Our Ref: ID 3530
Your Ref: SSD-66876472

EIS for State Significant Development Application Berrima Hotel SSD-66876472

Lower Basement

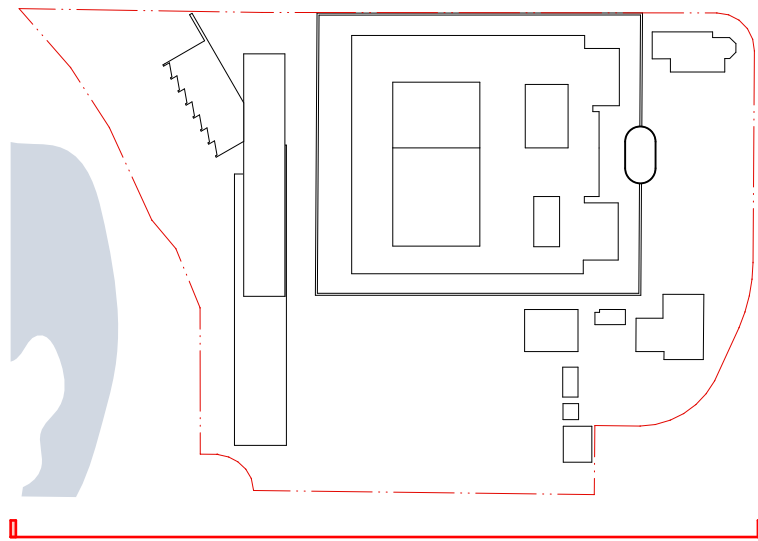
- **Recommend** designing openings to the basement (ramp, vents, etc) to be situated above the Probable Maximum Flood (PMF) or 1% AEP plus freeboard, whichever is higher, if possible. If this is not feasible reconsider basement carparking as any openings to the basement are below the PMF will pose risk to life and property.
